Further to your email to Damien on 7 April 2022, we have completed the assessment for the s4.55 Modification for Huntlee proposal.

I have attached a spreadsheet of the SIDRA model review listing items for clarification regarding the assumptions used and calculation of future volumes for your review and comment.

WR 556 SIDRA Model Review Review findings					
Status	Scenario ID / Section	Intersection	Category	Review comment	Model developer response
Minor	WCD Triton (All scenarios)	Wine Country Drive / Triton Boulevard	Volume	We request that the proponent provide a breakdown of the LV/HV volumes within the report. Given that the proponent undertook the count in 2020, this should be made available. The counted values for heavy vehicles should be used if available, instead of %.	
Medium	All	All	Volume	We request that the proponent confirm trip distribution assumptions that have been used. Has the trip distributions been adopted from the original Stage 1 Hyder Traffic Report which was completed in 2012?	
Major	2023 plus Scenarios	All	Volume	We request the proponent to provide calculation of the future flows (both for the additional 900 lots and additional 1350 lots scenarios) - trip ge

Figure 4 – AM peak 1950 lots being 2023 flows (600 lots) plus additional 1,350 lots

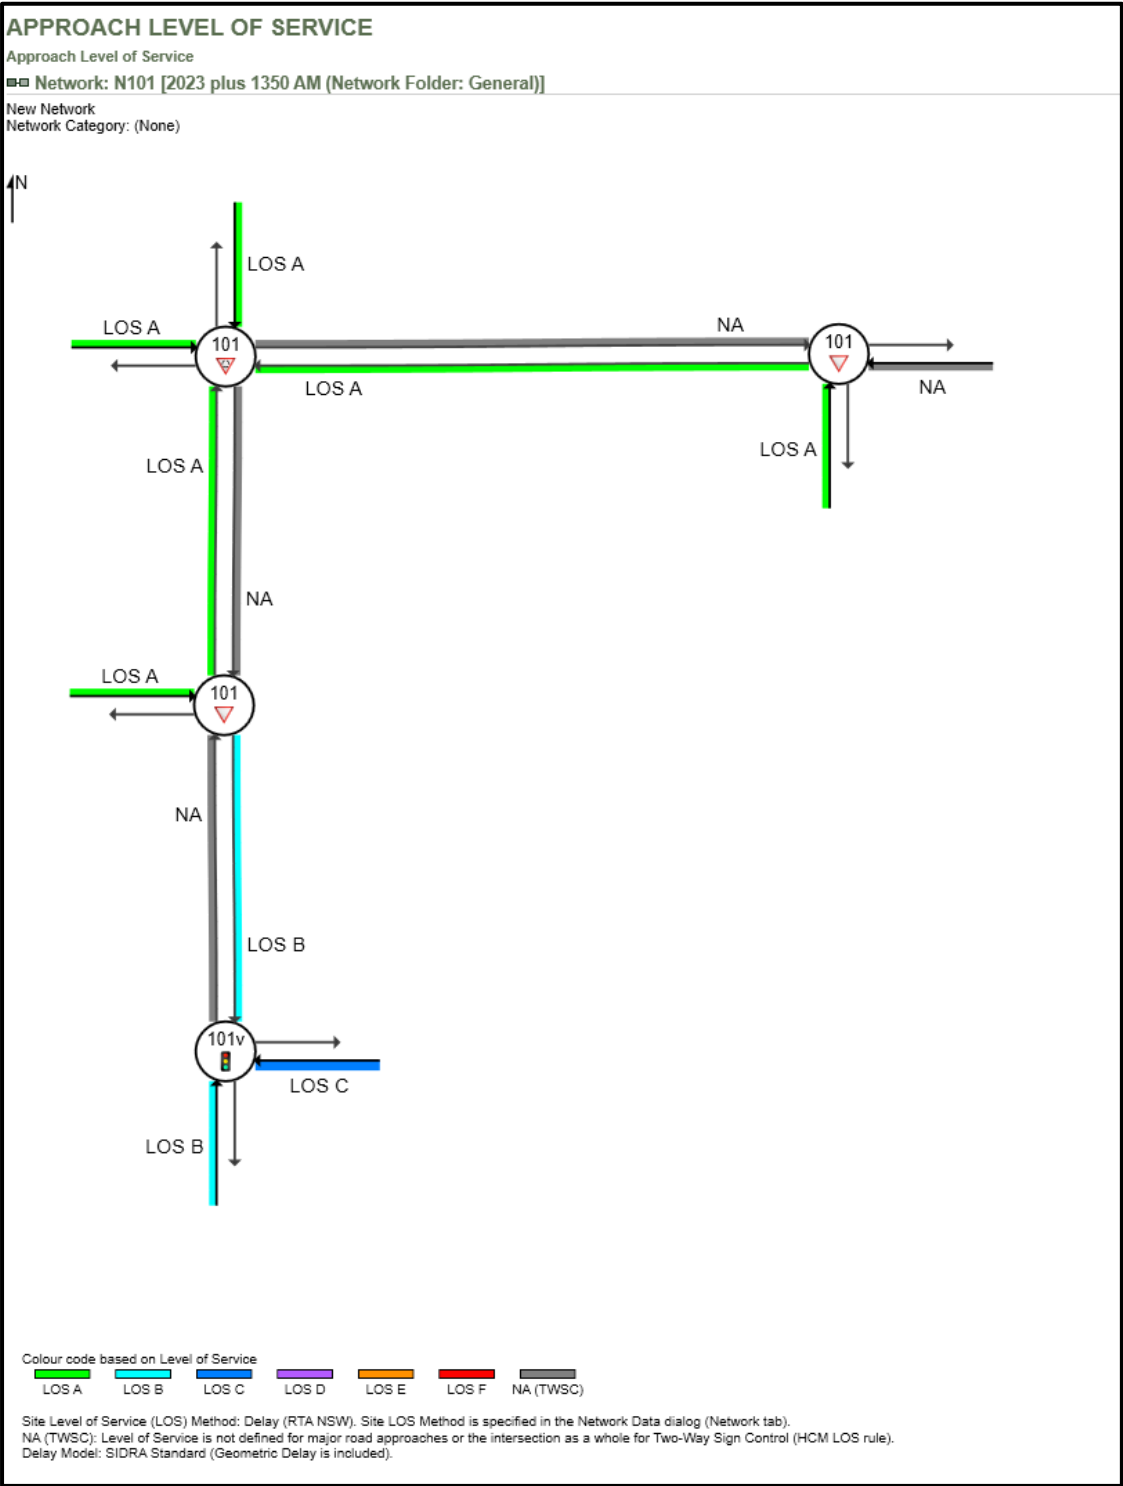
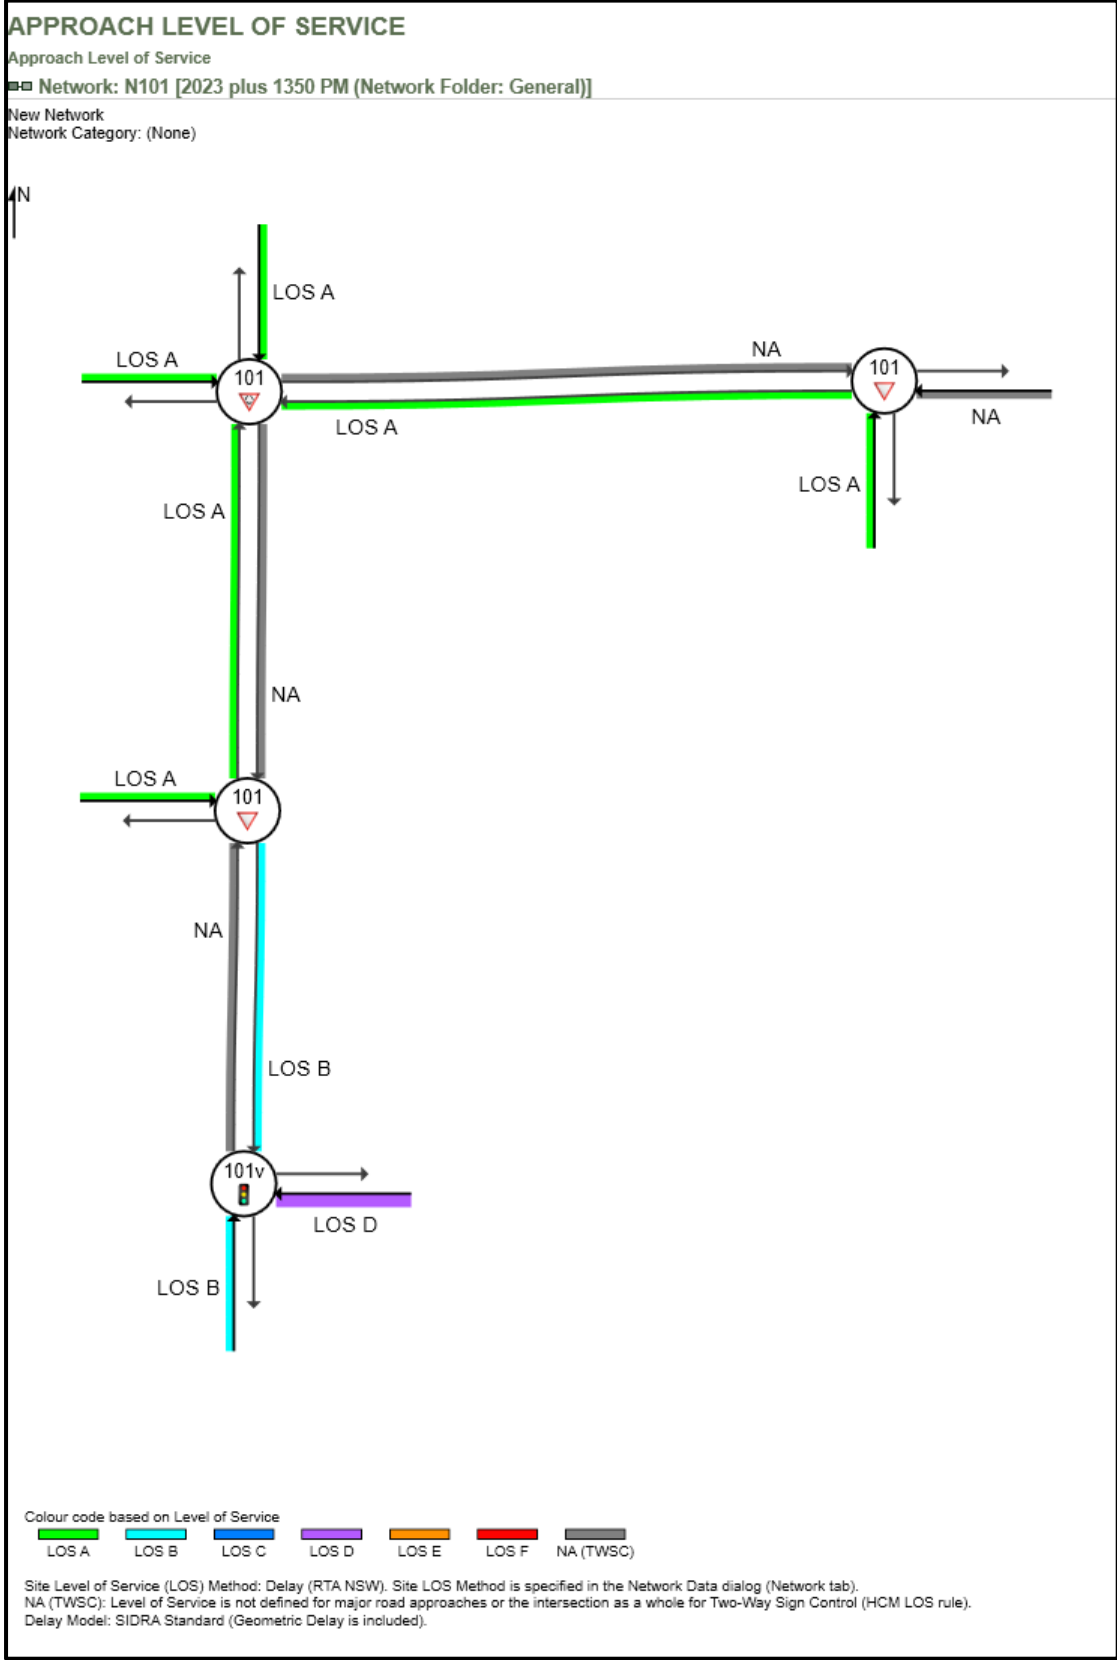
Info required	All	All	Volume	We request that the proponent provide justification of the changes to the default growth rate (specifically the growth rates adopted) - is this for sensitivity testing?	
Medium	Winepress (All scenarios)	Winepress Road / Wine Country Drive	Gap Acceptance	TWSC Calibration should be turned off as this will reduce the actual critical gap and follow-up headway values used by SIDRA.	
Medium	LinLout HEX (All scenarios)	HEXLink Road / Link Road off HEX	Gap Acceptance	TWSC Calibration should be turned off as this will reduce the actual critical gap and follow-up headway values used by SIDRA.	
Medium	WCD Triton (All priority controlled scenarios)	Wine Country Drive / Triton Boulevard	Gap Acceptance	TWSC Calibration should be turned off as this will reduce the actual critical gap and follow-up headway values used by SIDRA.	
Minor	All	Network	Network Data	Change maximum number of iterations to 60 before processing each network.

Medium	2023 plus 900 & 2023 plus 1350 scenarios	Network	Midblock	Volumes should be checked as the differences in midblock flows are quite large (>100) within the network - this also appears in the diagnostic messages for these networks	
Minor	WCD Triton (Signal scenarios)	Wine Country Drive / Triton Boulevard	Lane Movements	Left turn on the east approach enters the short lane on the south approach. It is recommended to first utilise the full lanes before allowing vehicles to turn into a short lane.	
Major	Base and 2023 plus 900 scenarios	Network	Network Layout	We request the proponent to justify why the Wine Country Drive / Triton Boulevard intersection was not modelled with the network.	
Major	WCD roundabout (Base scenarios)	Wine Country Drive / HEXLink Road	Lane Geometry	We request the proponent to justify why a u-turn movement has been specified for the east approach lane for the 2023 + 900 & 2023 + 1350 scenarios but not for the base scenarios.
